CITY OF ALBUQUERQUE

October 28, 2014

**Re: TLC Pet and Uptown Cat Hospital
Grading and Drainage Plan
Engineer's Stamp Date 10-14-14 (J20D027)**

C001

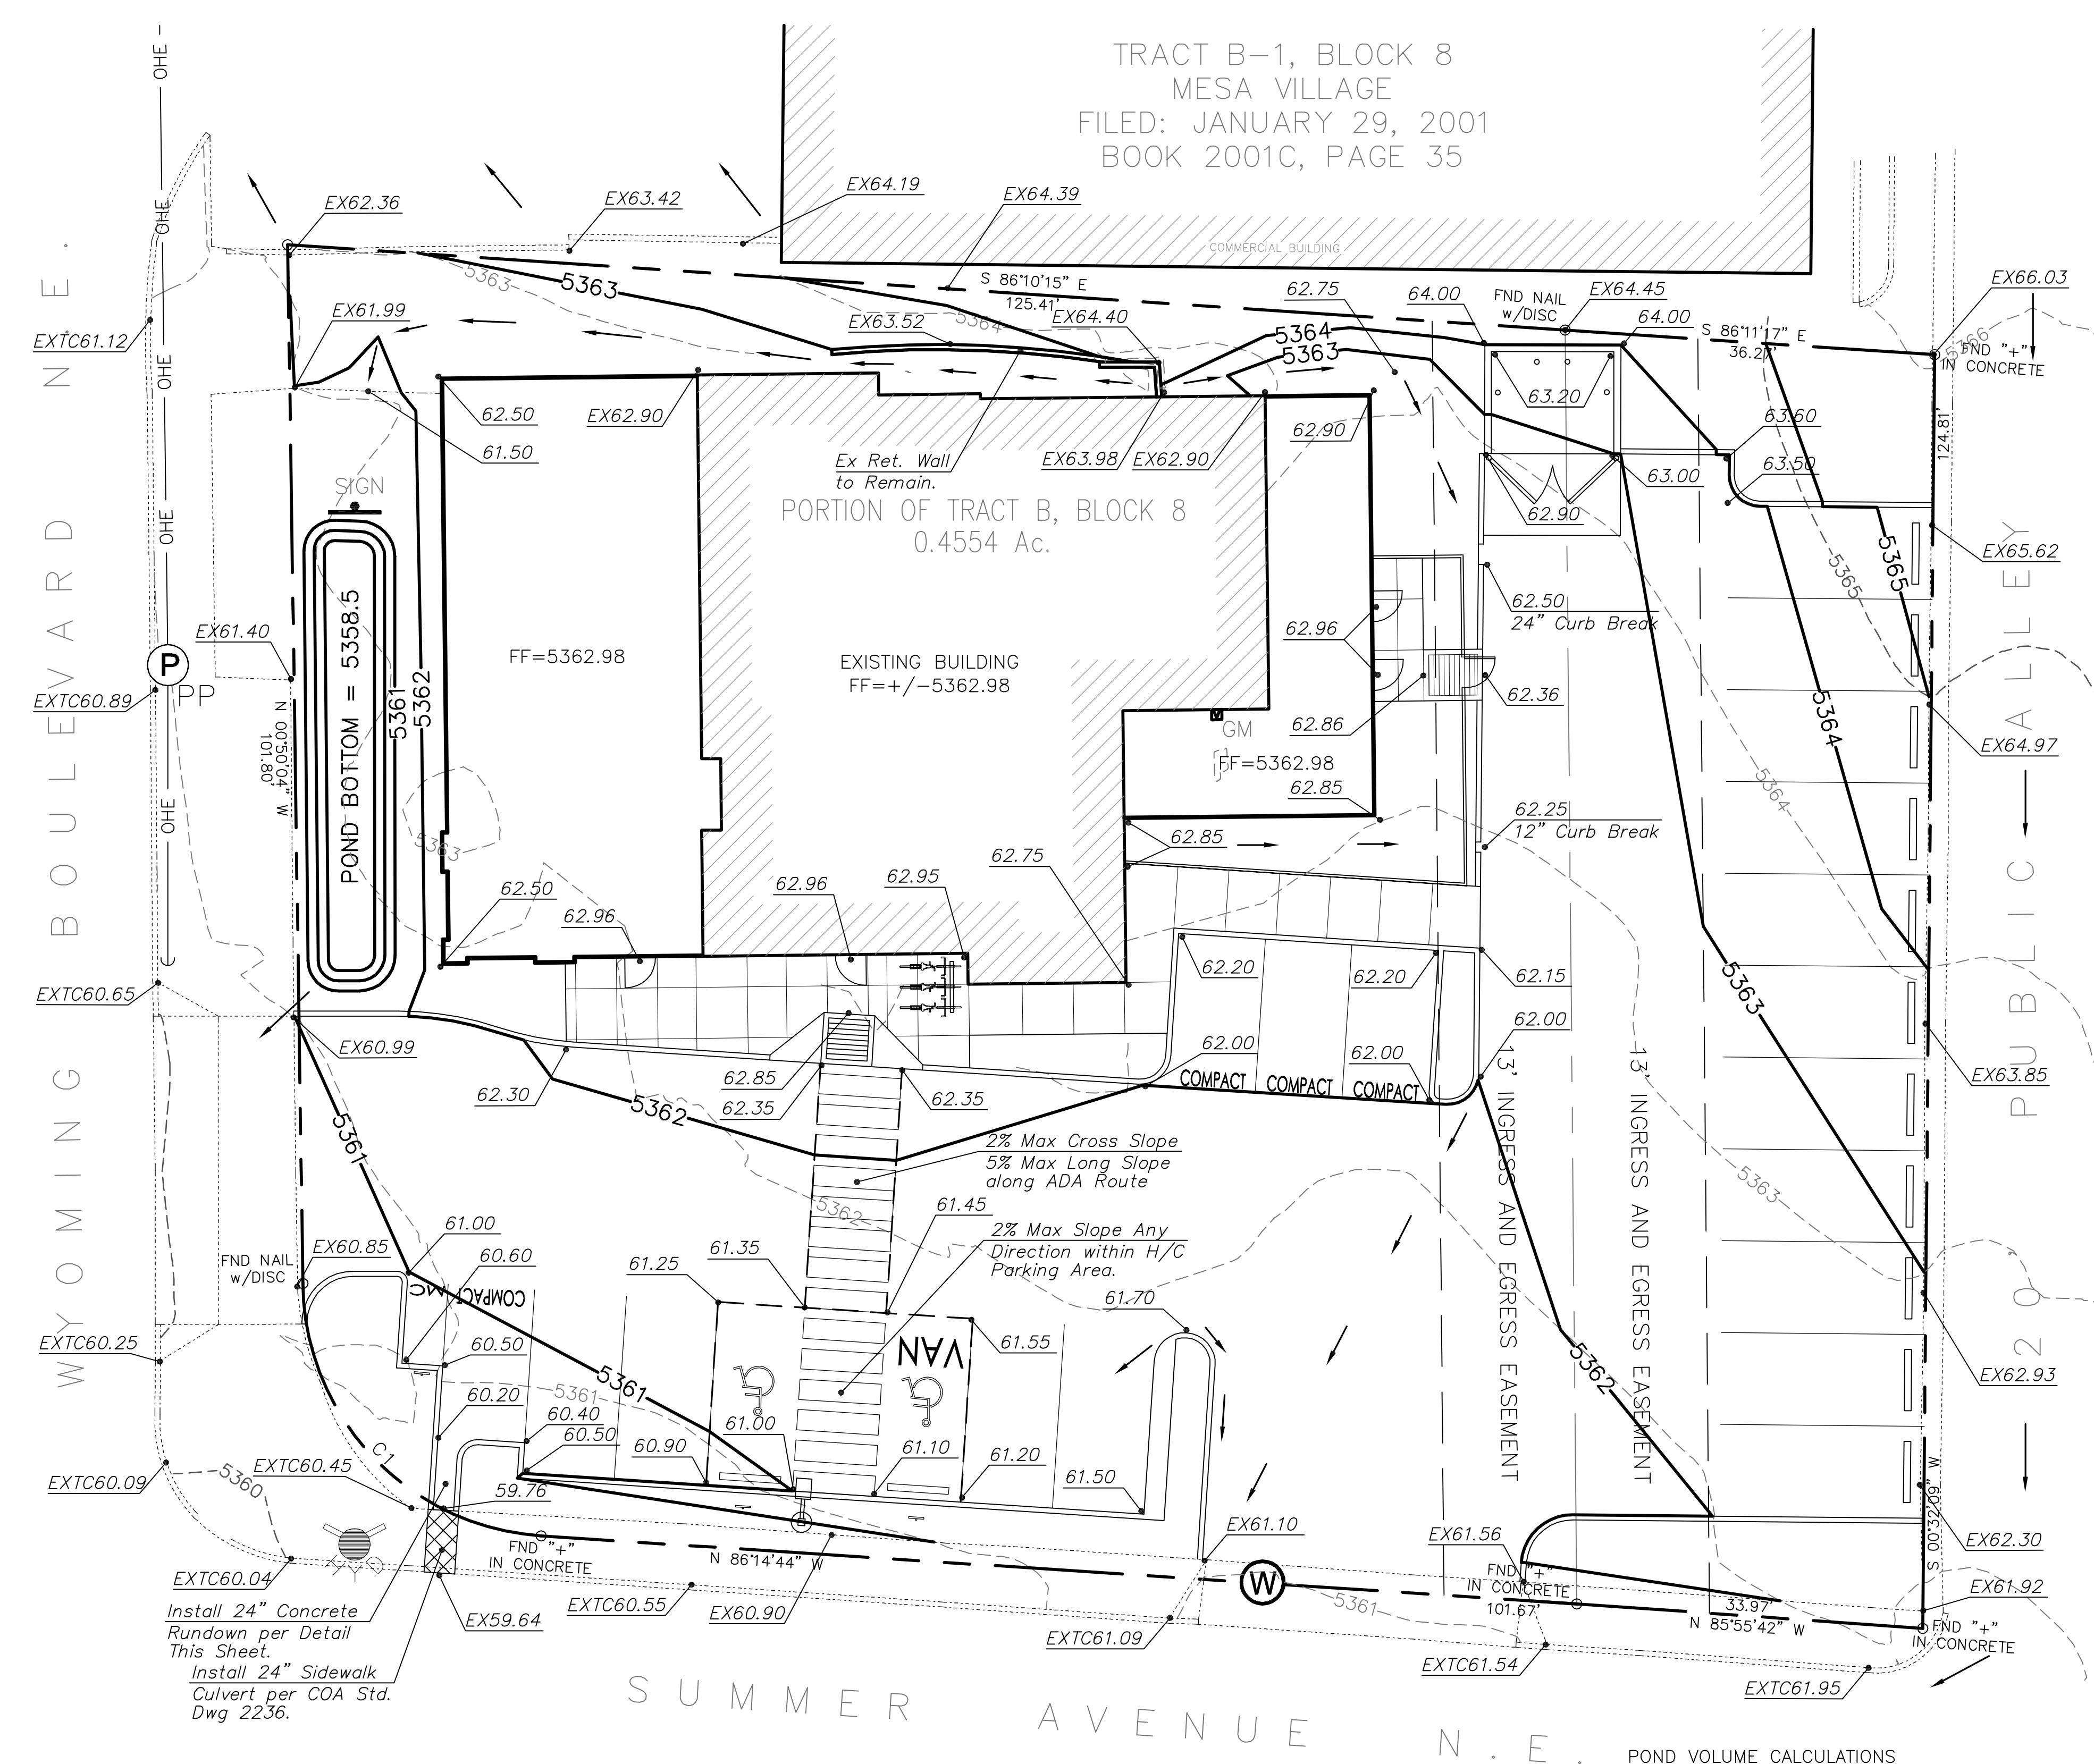
1. A S0-19 permit is required for this site because of the sidewalk culvert. The standard language is attached. Add this to the drawing. Also include a signature block for the City Inspector. Request S019 approval with the next submittal in addition to the Building Permit request.
2. The First Flush requirement is 0.34 inch multiplied by the impervious not 0.44 inch as shown on the plan. The 0.44 inch is reduced by 0.1 inch for the initial impervious abstraction in Table A-6 of Section 22 of the DPM. Not as much needs to be retained as stated on the plan.
